Permit Number: 050715

has permission to Building 2 - 2 Family Dwelling Units 49, 43

AT 0 Lane Ave Jarita Court 308 A001001

SHARP HOMES INC.

1 RATED INTERIOR PARTITION PLAN VIEW 1/2" = 1'-0"

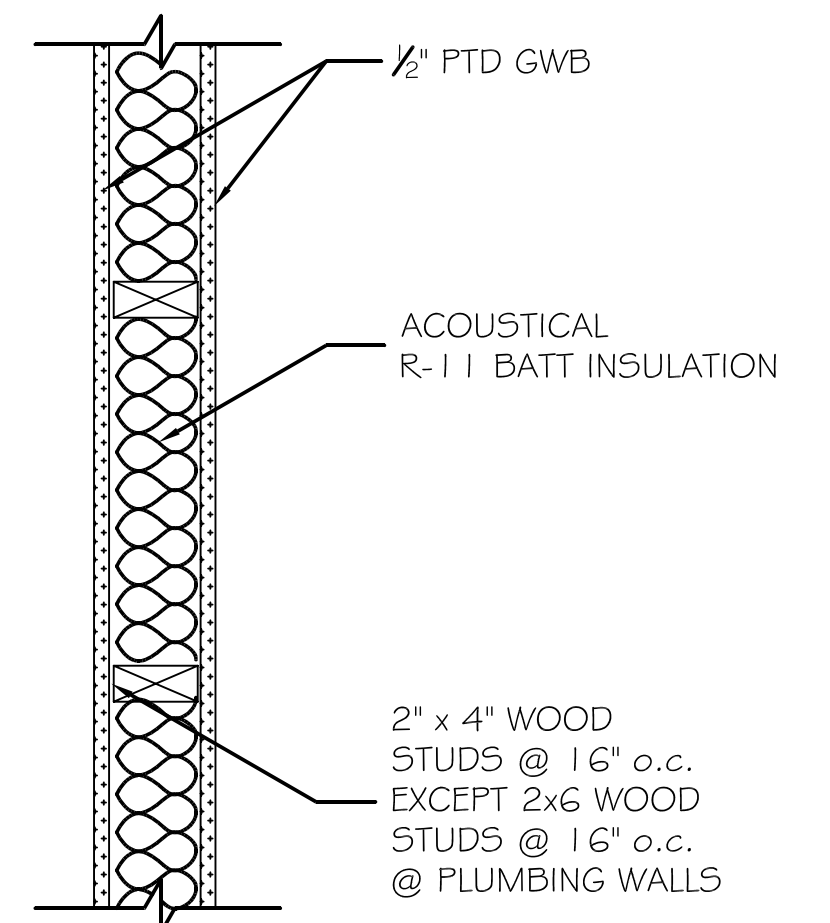
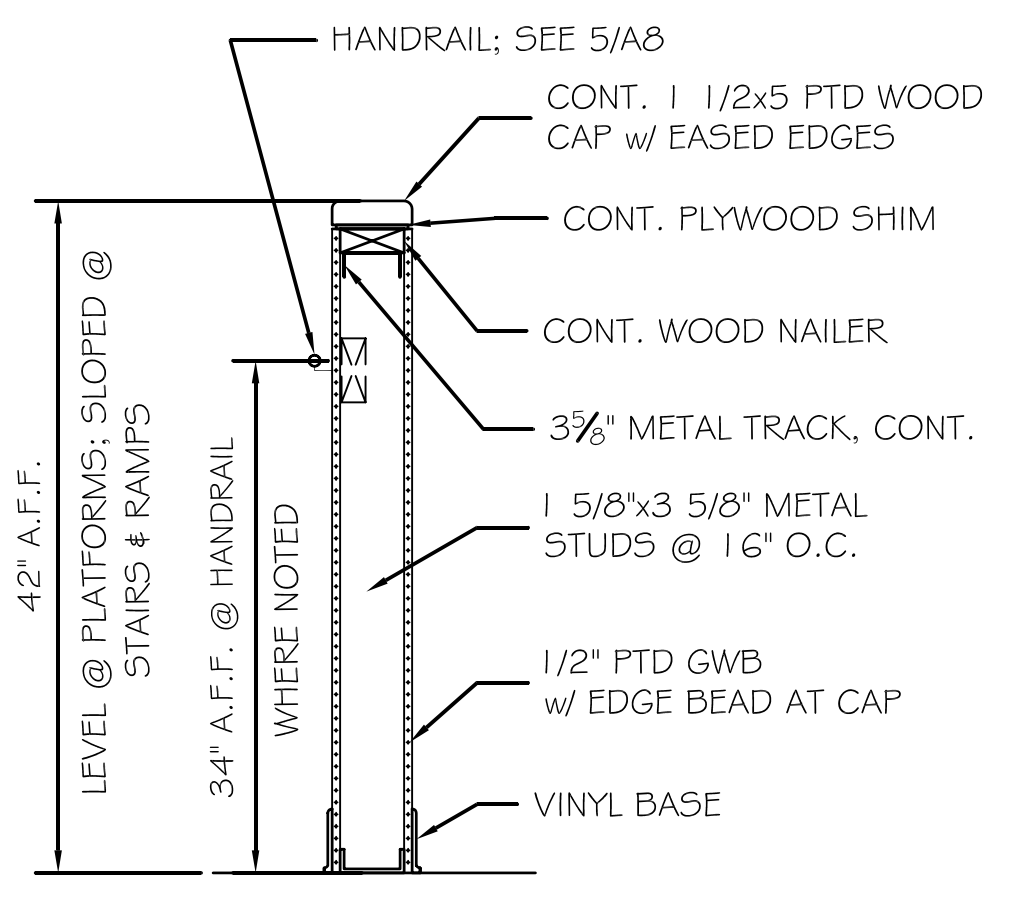
- ✓1. Verification of sheet rock under stairs on first floor
- ✓2. Paradigm Window Manufacturer Verification of egress windows.
3. Have shown Attic scuttles (Typ)
- ✓4. Have shown minimum headroom in stairway.
- ✓5. Have shown 1hr. rated **beam** enclosure in garage.
- ✓6. Please find enclosed data on the common wall detail, double staggered studded wall with STC rating of **57** with use of Acousti/block product see enclosed information sheet.

2x6 plates
7x4 studs staggered
3" insulation
Acousti/block
weaved between studs
